Application for a non-material amendment following a grant of planning permission.

Number	
Suffix	
Property name	Street Record
Address line 1	Swallows Gate
Address line 2	
Address line 3	
Town/city	Angmering
Postcode	BN16 4EN
Description of site location must be completed if postcode is not known:	
Easting (x)	507260
Northing (y)	105051

demolition of existing buildings and construction of 18 new build dwelling and refurbishment of existing dwelling

change to dwelling drives from resin bound to porous block paving

| DRAINAGE LAYOUT |            |                            |          |

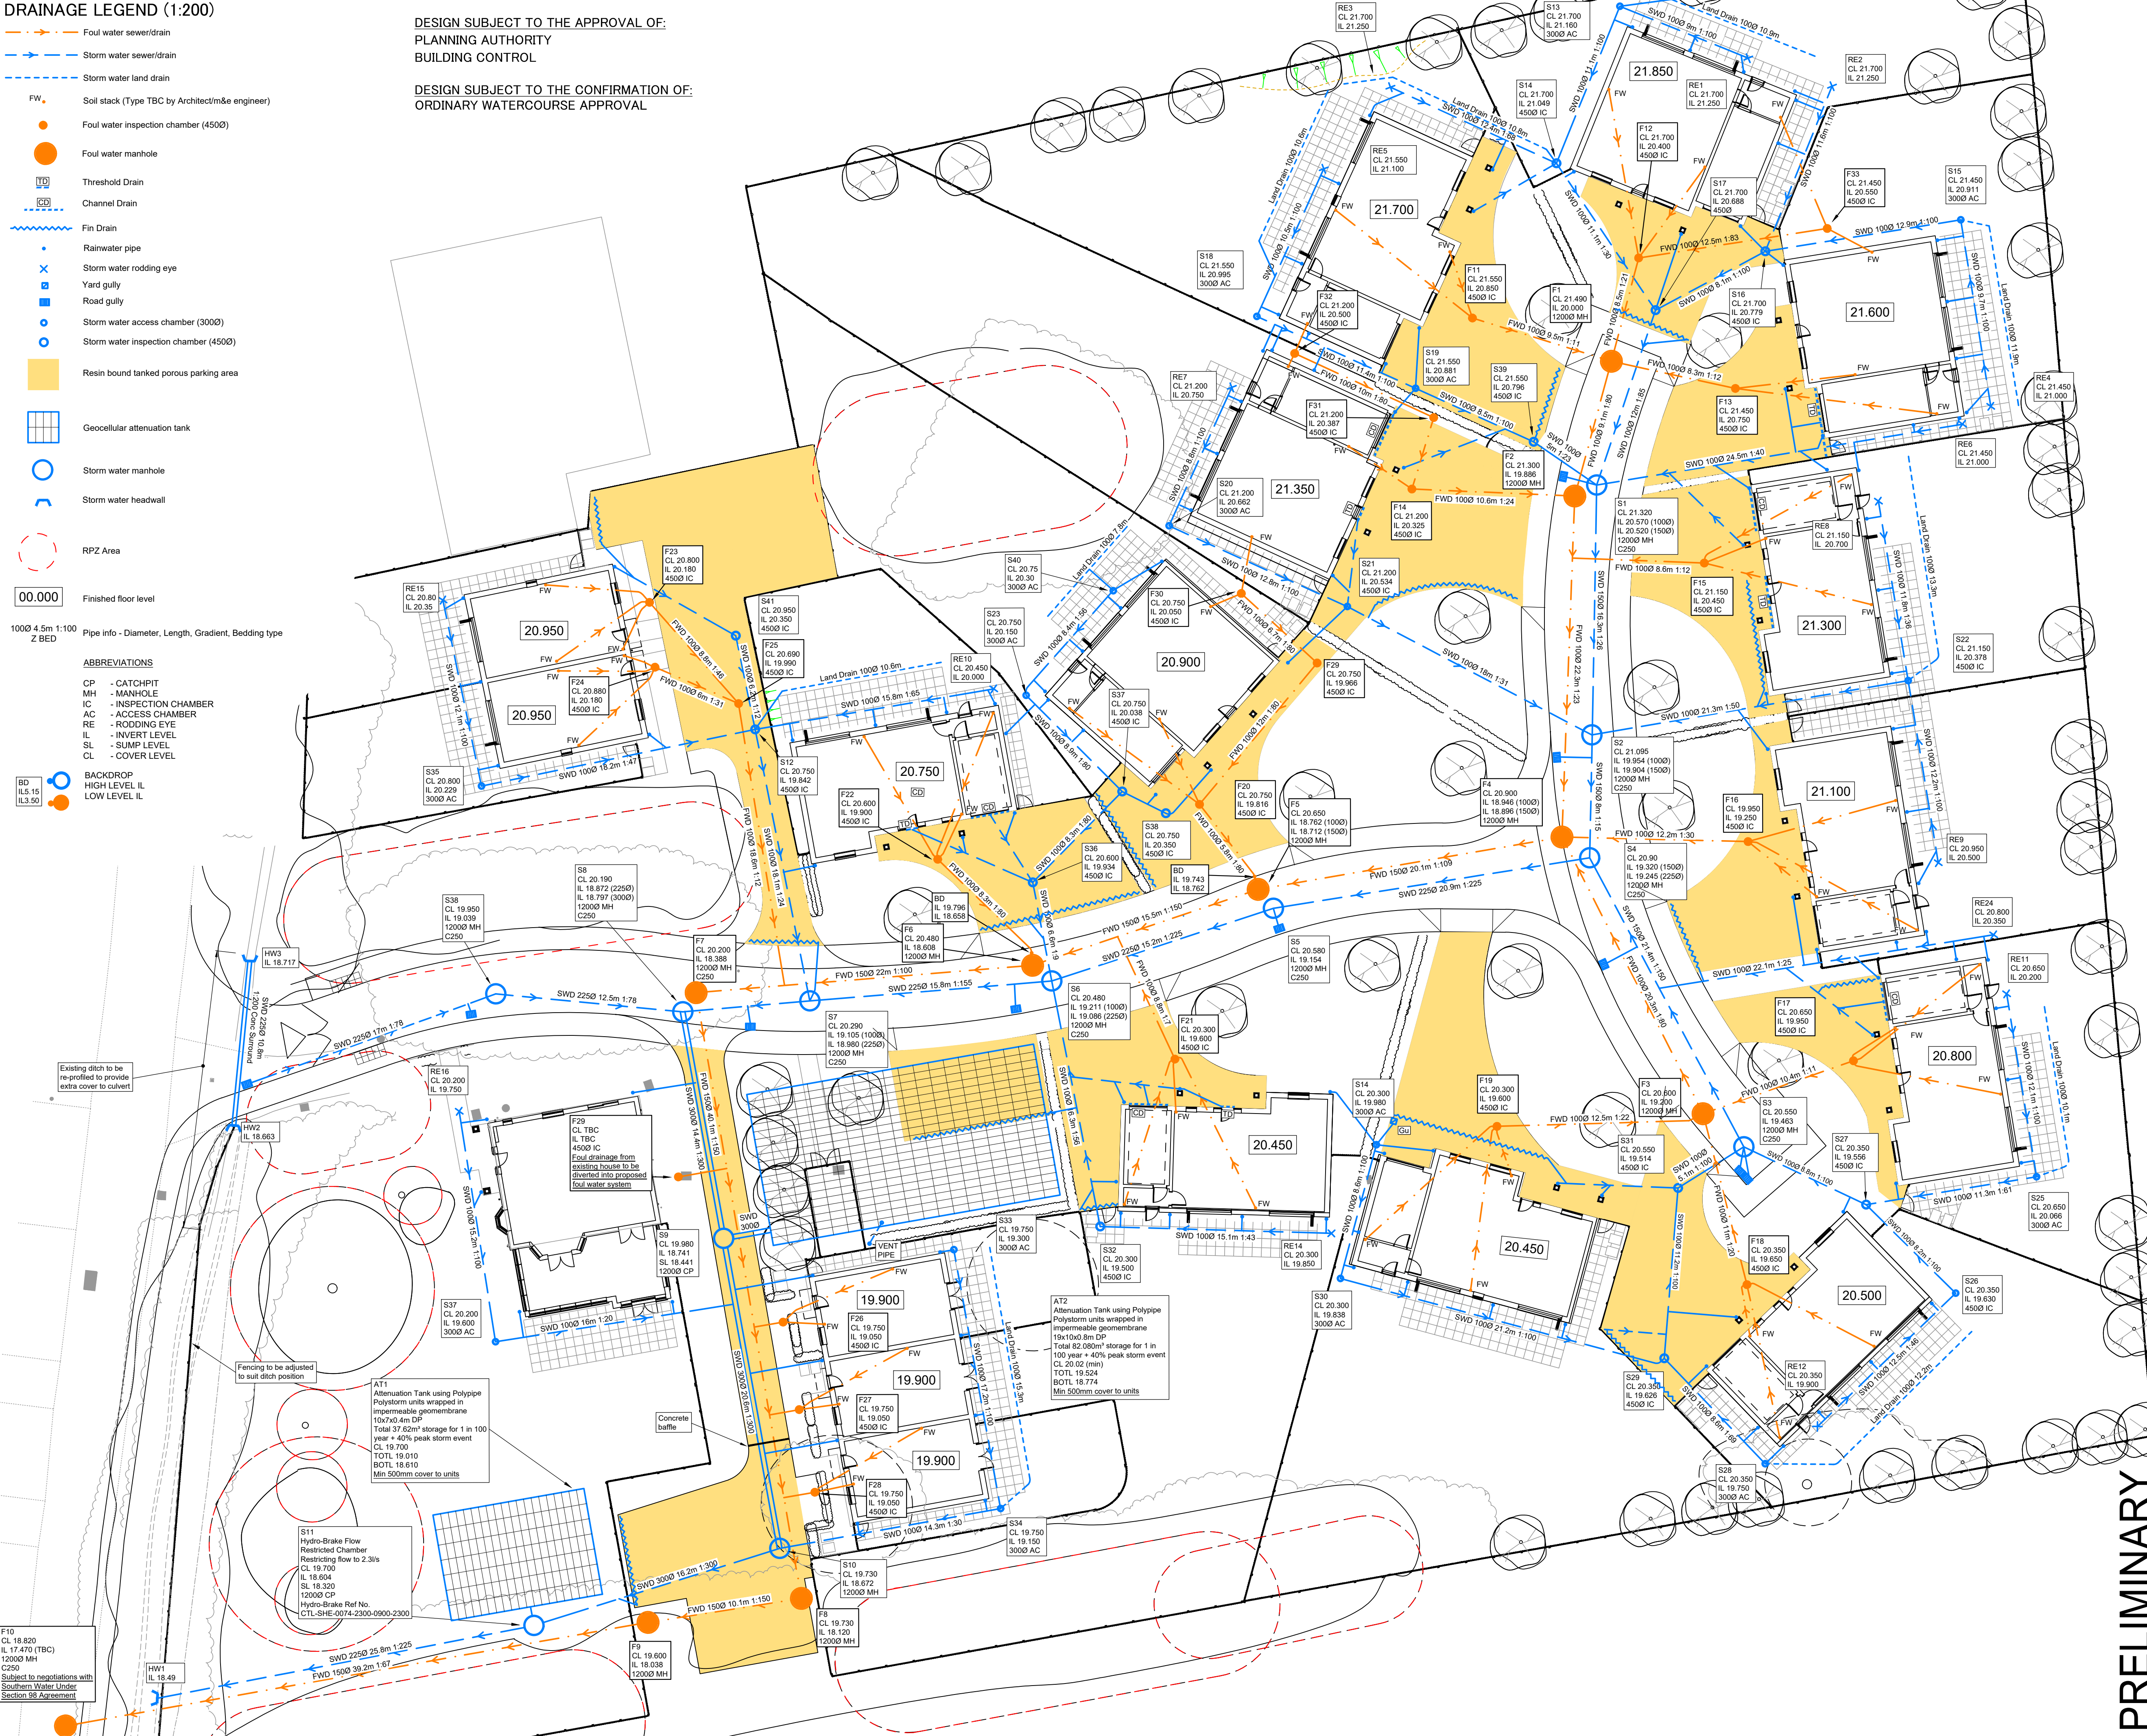
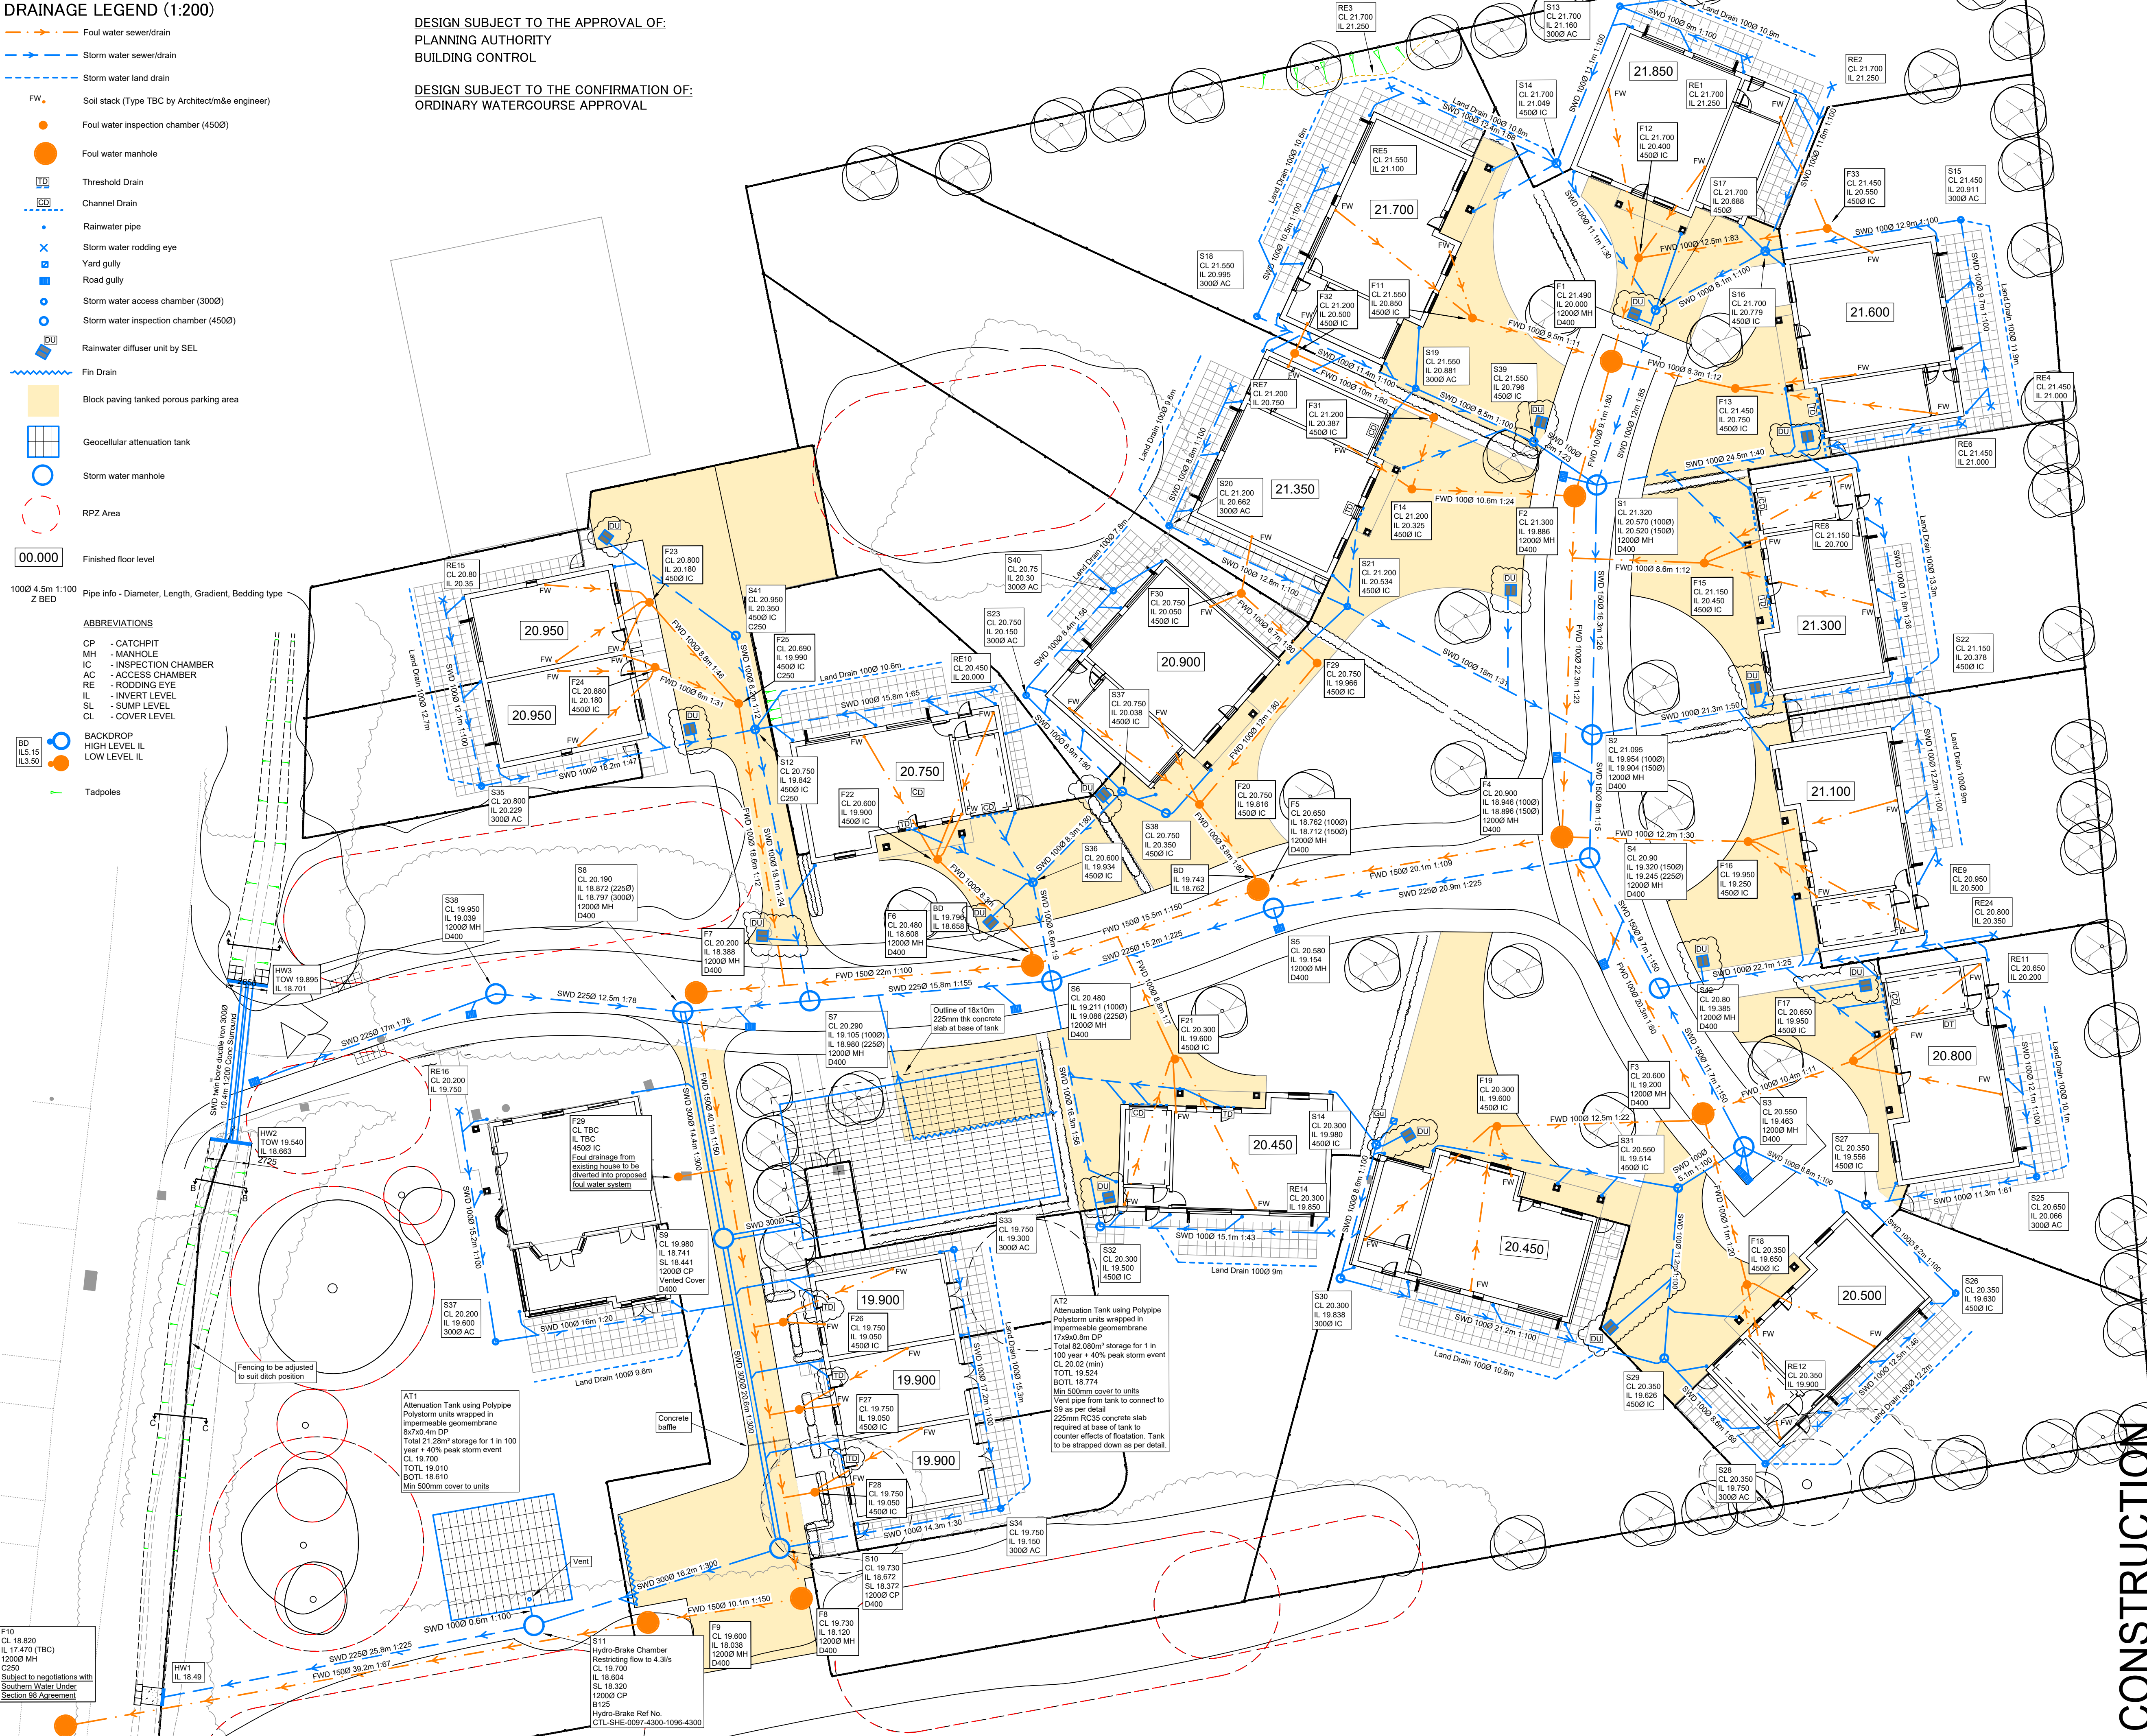
C1429/100/P2 - Drainage Layout (Ref: A/132/19/DOC)
Materials Schedule

the change requested/made from resin bound gravel drives to porous block paving has been made to aid the draining of the driveways from the surface water and to provide a more robust and attractive finish to the drives

C1429/200/A External Works Layout
